Subject: Objection to planning A/18/8/PL

Reference: A/18/8/PL for Application for Variation of Condition 2 imposed under A/173/16/PL to read "the development to be carried out in accordance with the following approved plans ADC962/04 REVA, ADC962/13 & ADC962/14 relating to revised position of rooflights on east, north & south elevations. This application affects the Character & Appearance of the Angmering Conservation Area at Land Rear of 1 To 6 The Cottrells, Angmering

Location: Land Rear of 1 to 6 The Cottrells, Angmering

Ref: Drawing ADC962/14: Elevations and Sections:

A		Layout amended		10.11.17	
Rev		Description		Date	
Job Reference		Client			
New House The Cottrells Angmering, BN16 4AF		AM Homes Ltd			
Drawing Title		Drawing No		Rev	
Ground Floor Plan		ADC962/04		A	
Date	Scale	Dwg Size	Plot Style	Drawn	Checked
24.04.17	1:100	A3	ADC-red	TGS	AD

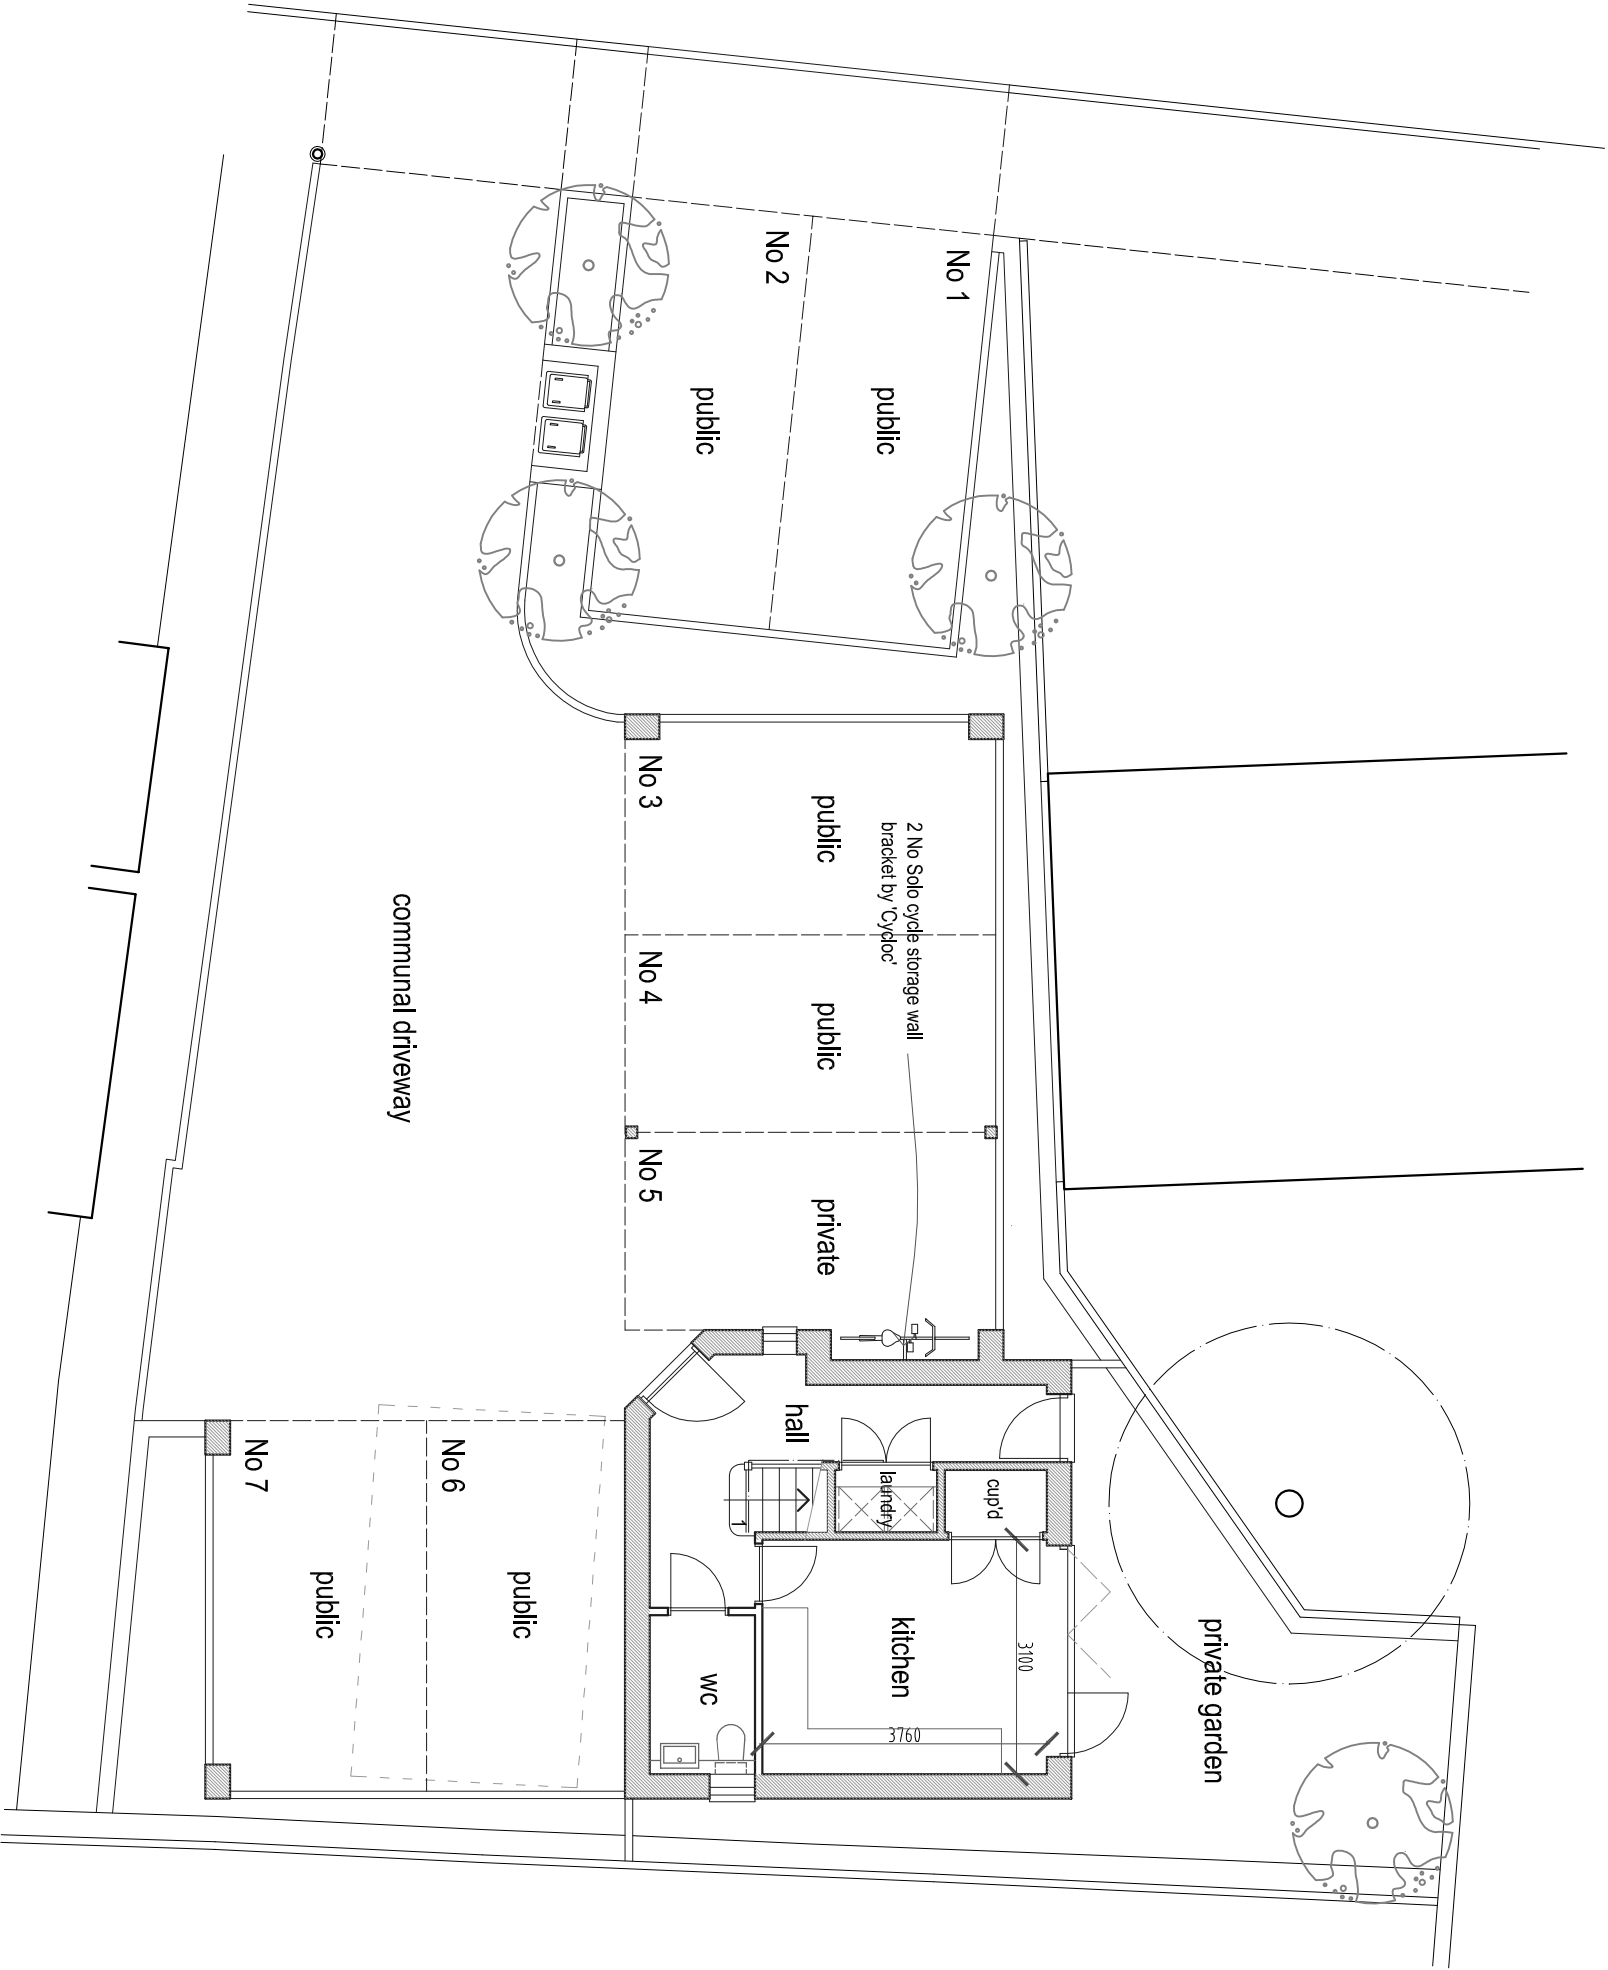
I also understand that contrary to the plans, and observing the work going on, plumbing has been installed for a kitchen upstairs, not downstairs as per the submitted plans. Again, this shows that the builder had no intention of following the submitted plans and relied on the inaction of ADC to circumvent this and thus construct a larger dwelling. This will have further impact on the occupancy of the property.

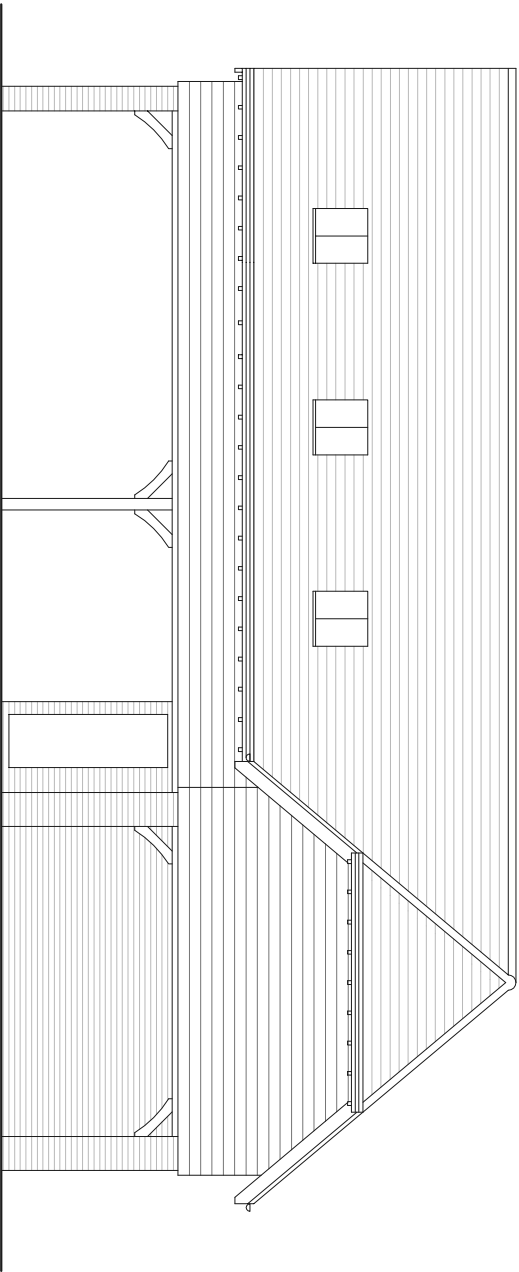
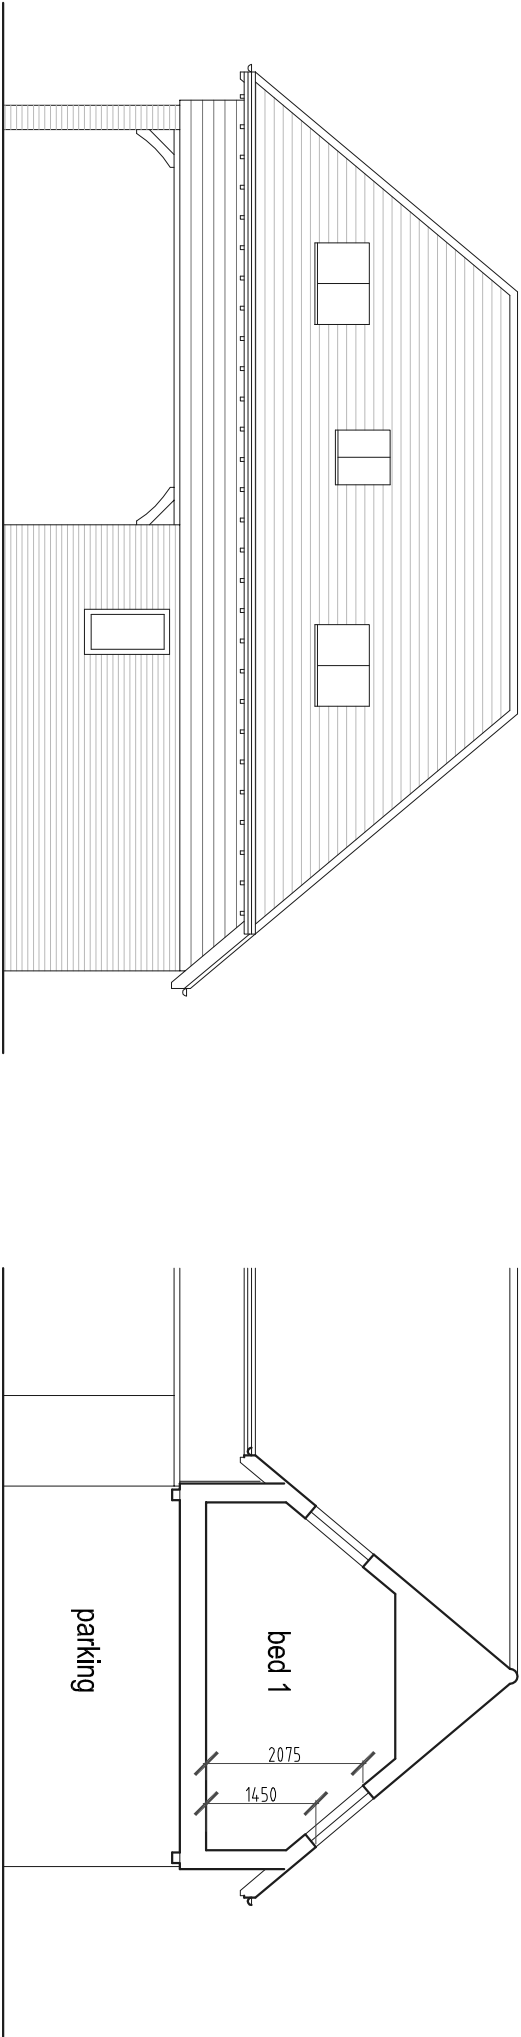
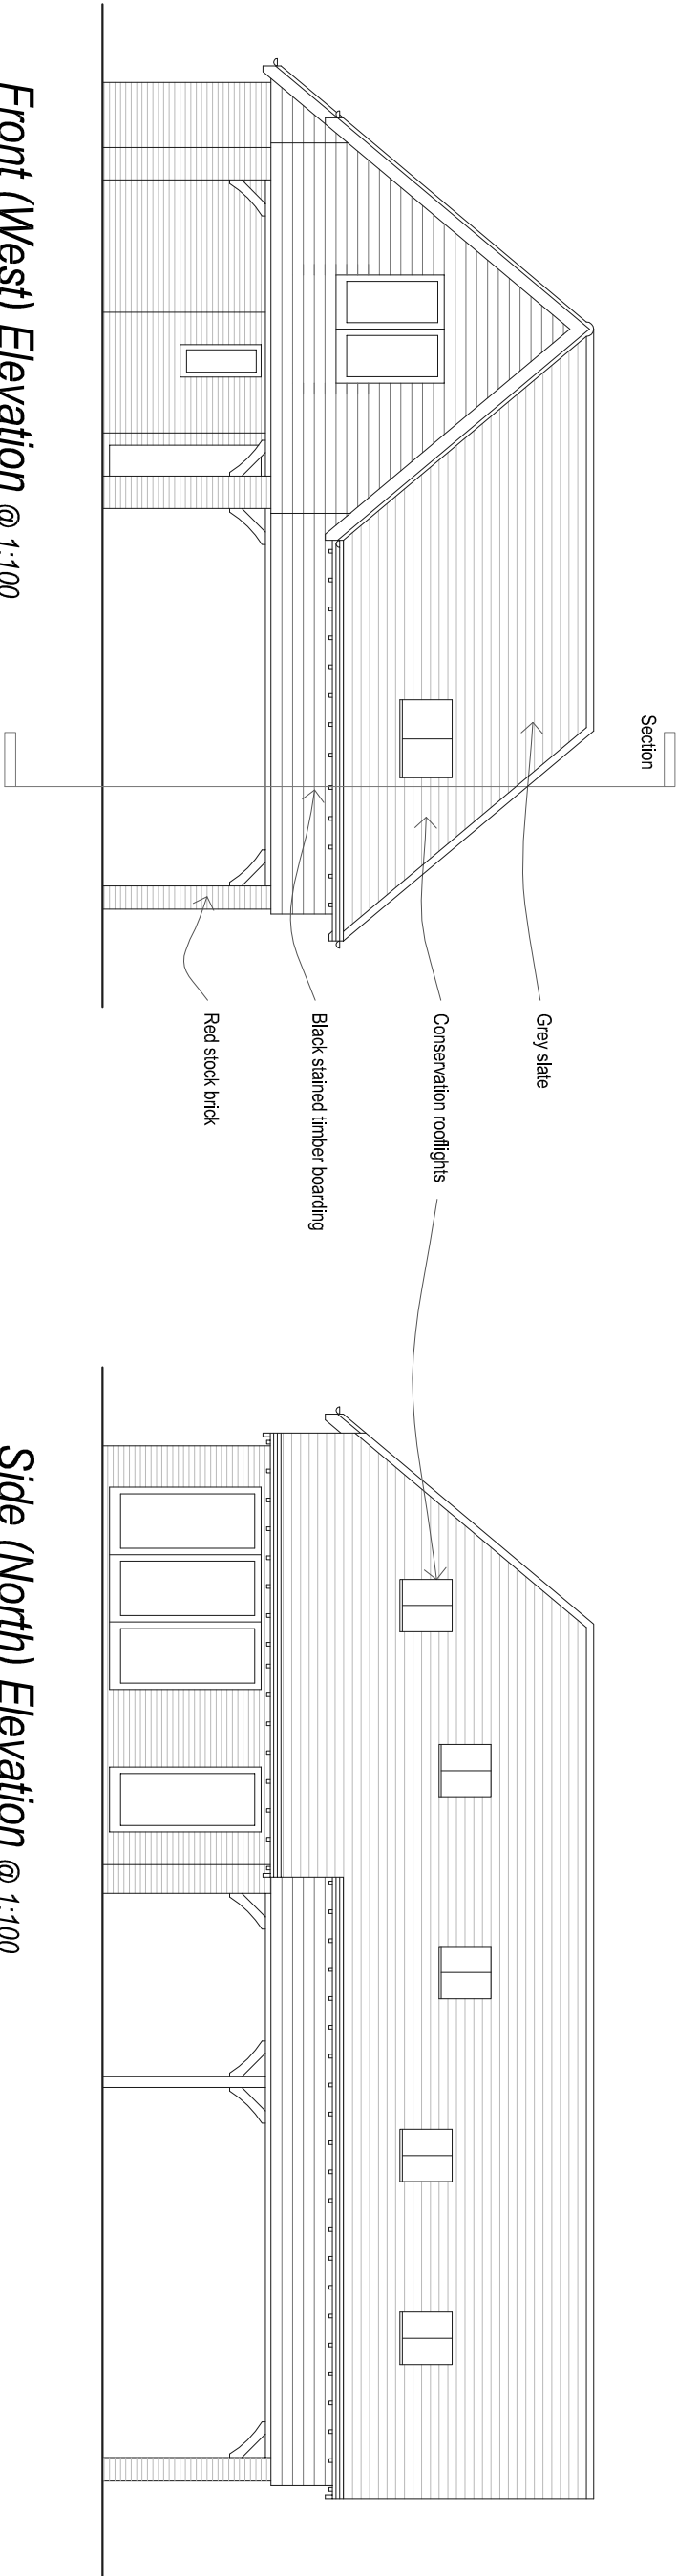
Further to the farcical approval of a dwelling which must surely be unique in the entire Angmering area, especially within a conservation zone, the current building is not consistent with the plans submitted to the ADC on a number of issues; these include a barn end instead of a hip end as per the original plans. The barn end lends the property an overbearing quality, blocking out the light and also ensuring that the property itself has more usable space, which was undoubtedly its intent. For the builder and contractor to arrive at this it must have been planned as such from the onset with the intent of deviating from the plan as the roof joists arrived prefabricated. As such, the contractors would have been working from a completely different set of plans to those submitted to the ADC.

The windows of the building were supposed to be rooflights, but instead are straight windows. From our property we can see straight through the building, and presumably the residents there will have an unhindered view straight into our house. As the windows are consistent with neither the submitted plans nor the conservation area, will they be forced to amend these?

The roof is taken back to the hip end the original approved application (A/173/16/PL) and the positioning of the building to be considered so that there is no overhang over the site's boundaries and all future maintenance can be achieved from within the site itself.

All the windows are removed and replaced with the escape roof lights on the agreed plans and are positioned according to the agreed plans.
